Project Title: Water Lane, Angmering

Project No/ Document Reference: A290-TN002

Date: 02 November 2020

DRAINAGE – HOLDING OBJECTION

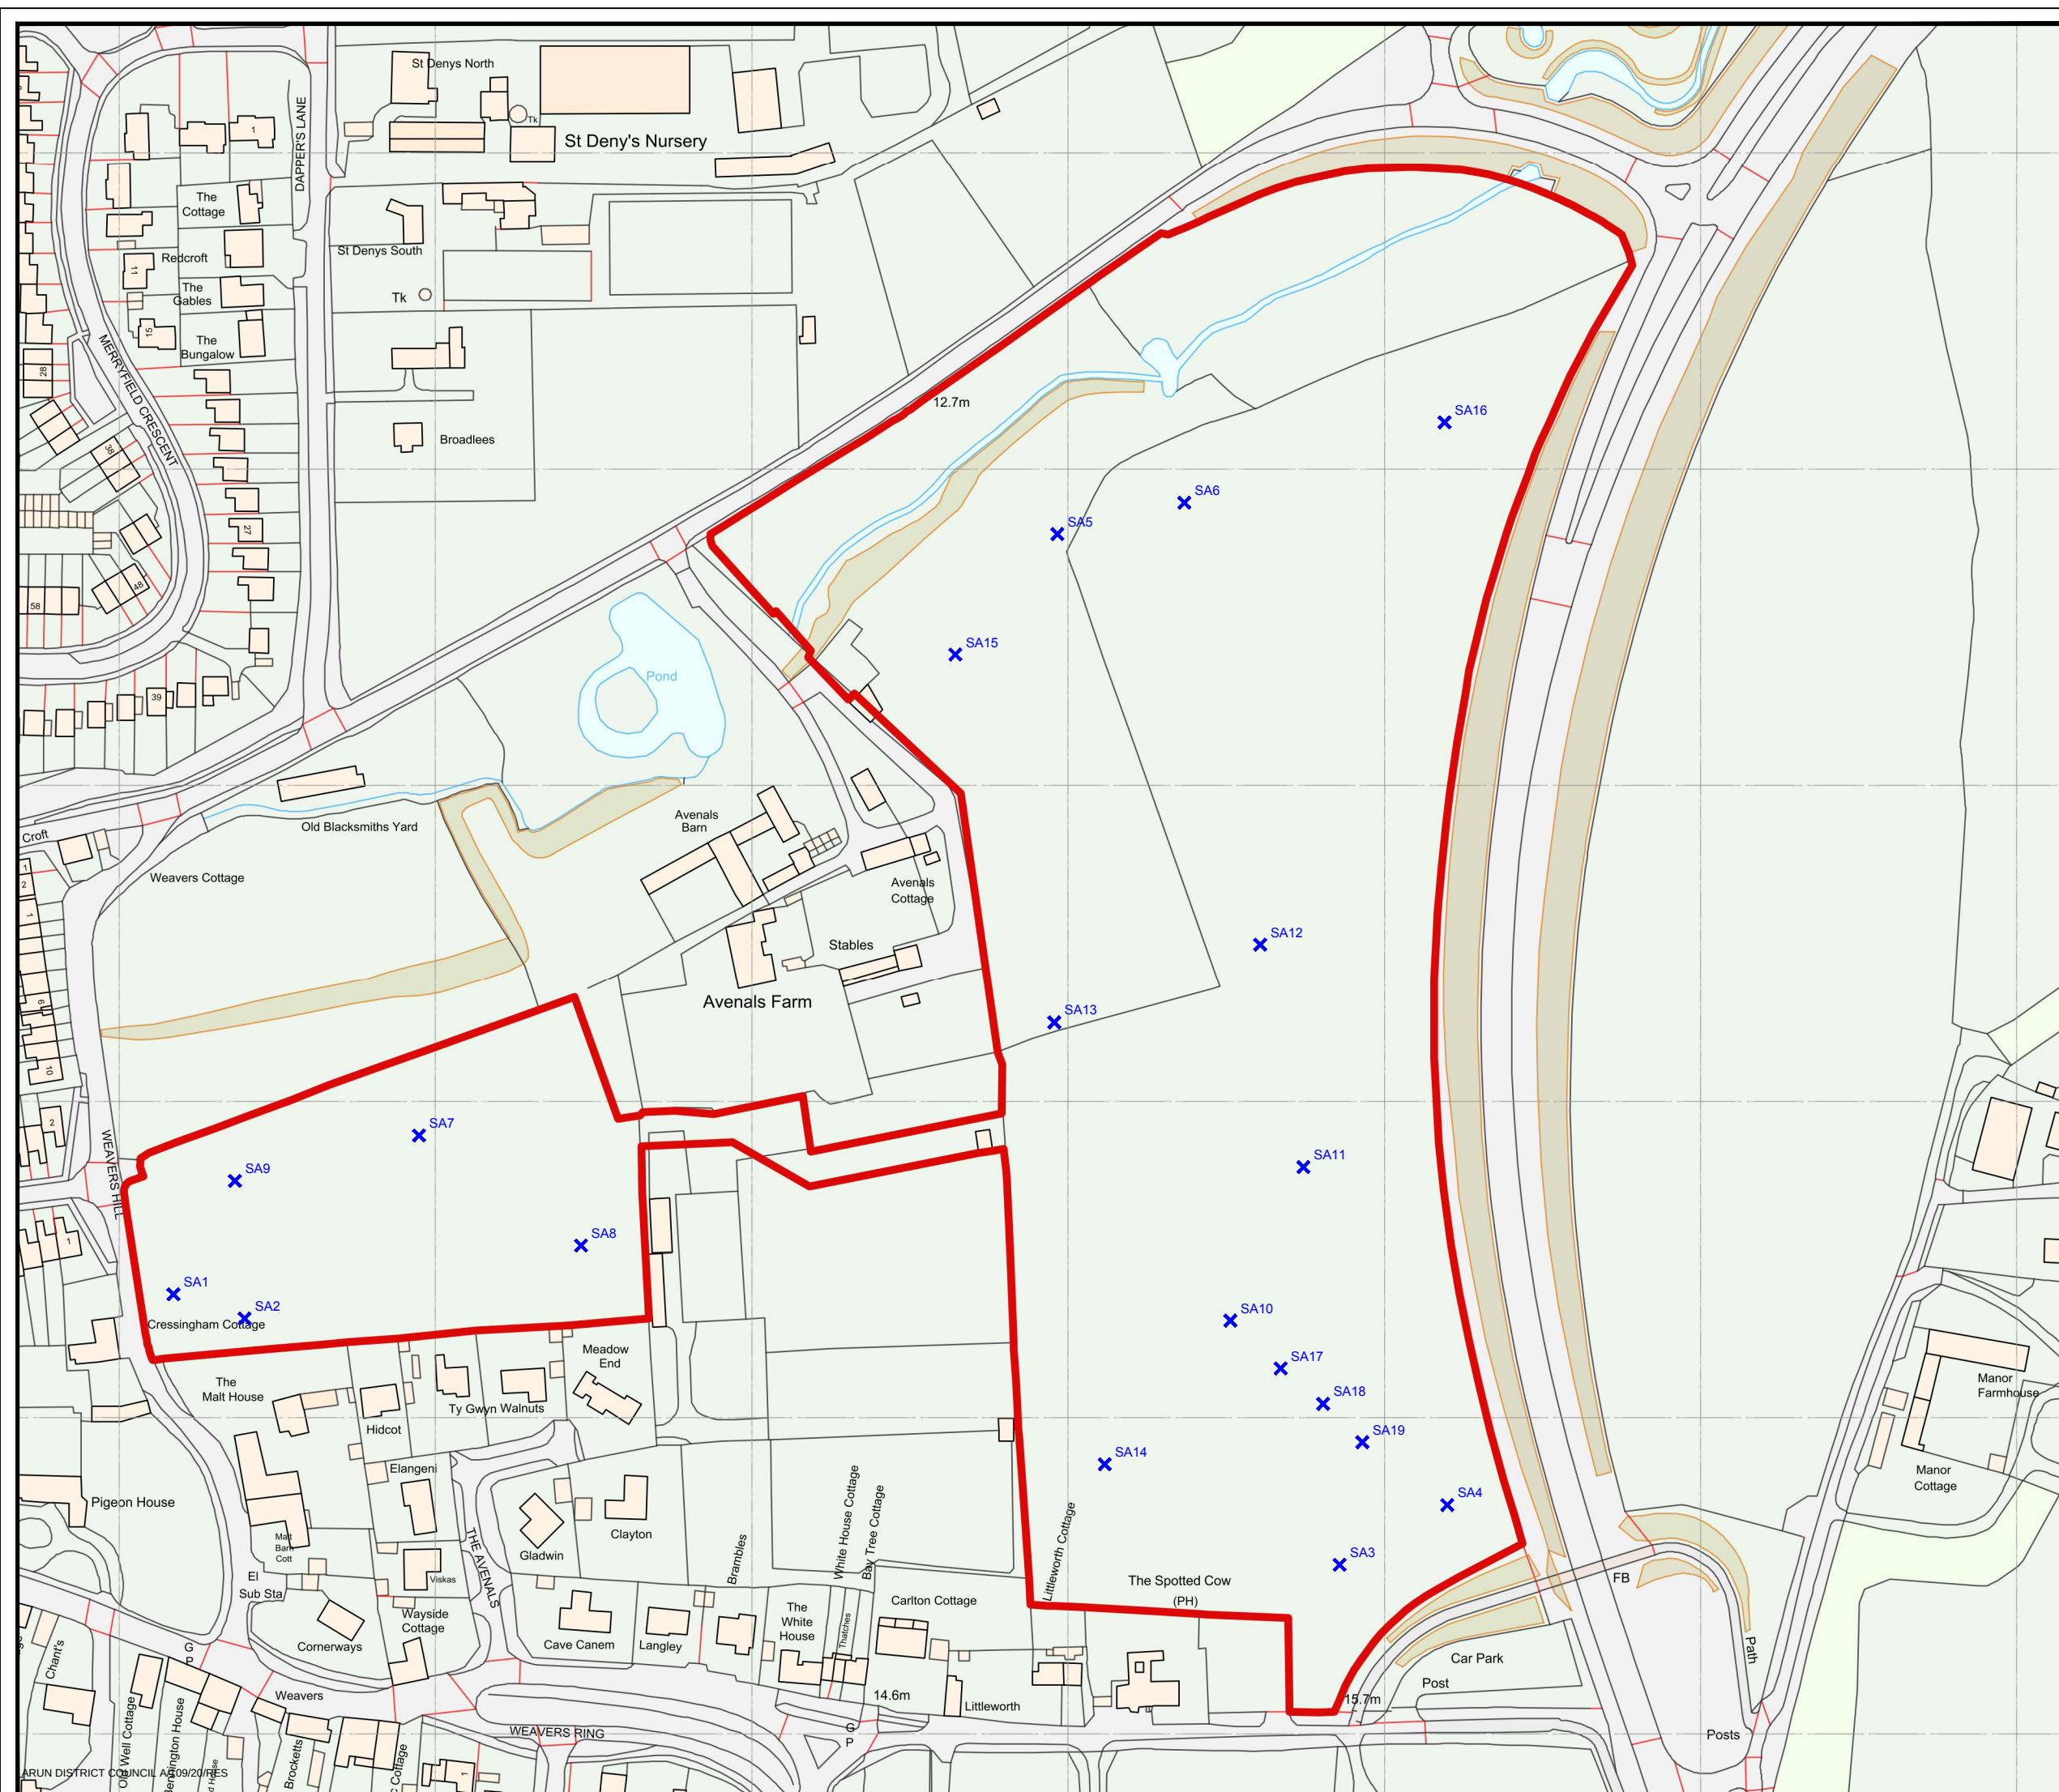
Worst case infiltration rates must be used in design.

It is assumed you refer to the use of average rates between trial pits in the vicinity of the infiltration device as opposed to across the whole site which would be wholly inappropriate. In some cases we used worst case rates and in others we used an average across 2 or more pits. This provides a rate consistent with the ground conditions that range over where the devices are located. However, we will provide calculations with worst case scenarios for the most appropriate pit in relation to the devices.

N.B. Following our telephone conversation we have used worst case infiltration rates, namely:

- Southern Basin – SA3 – 1.93×10^{-4}
- Western Parcel – SA2/SA1 – 4.52×10^{-5}

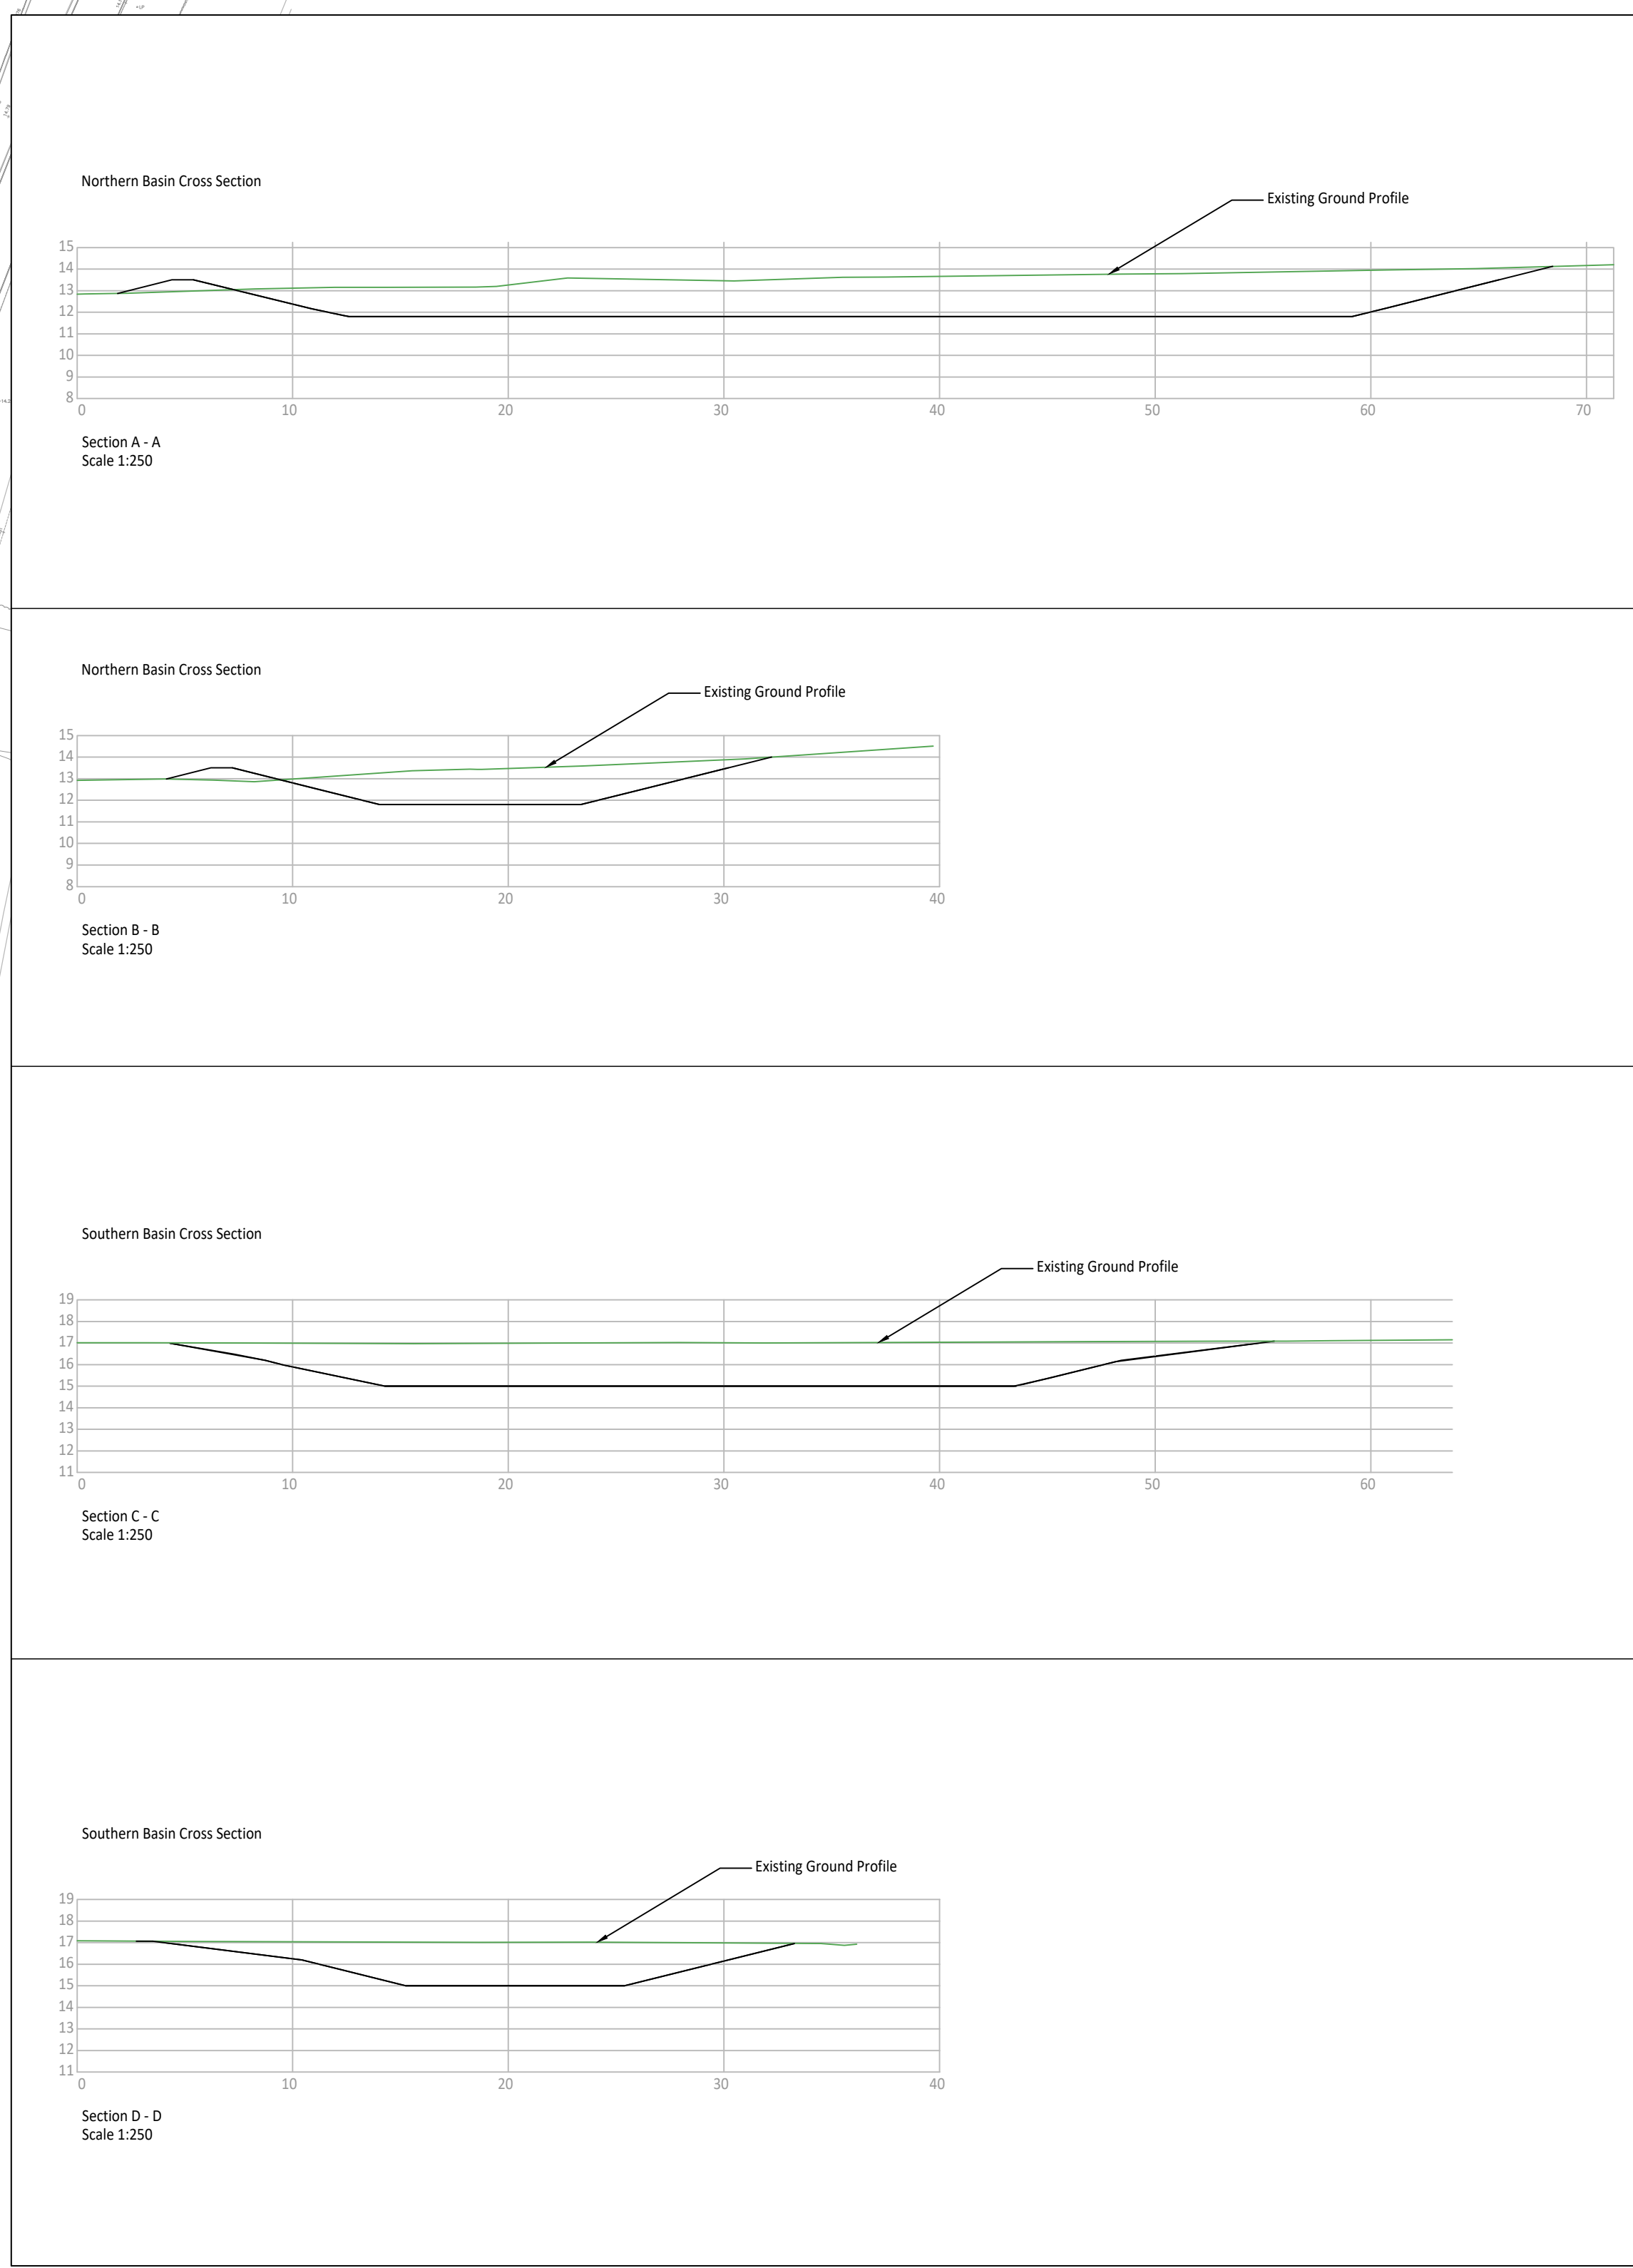
Please provide impermeable areas drawings in .dwg format to enable review.

We have included drawing A290-RM-512 P2, Post Development Catchment Areas and Basins, providing the impermeable area plan. Within the RM submission we included drawings A290-RM-501 and 502, Drainage Layouts Sheets 1 and 2, providing all proposed drainage levels and manhole numbers. In addition, within the submitted Drainage Statement (A290-R007) we included all Micro Drainage calculations including impermeable areas draining to each manhole. Therefore, all information has been previously submitted and .dwg are not required. However, we can include drawing A290-RM-512 P2 in .dwg format for your information.

N.B. Following our telephone conversation we have included the cad drawing for reference.
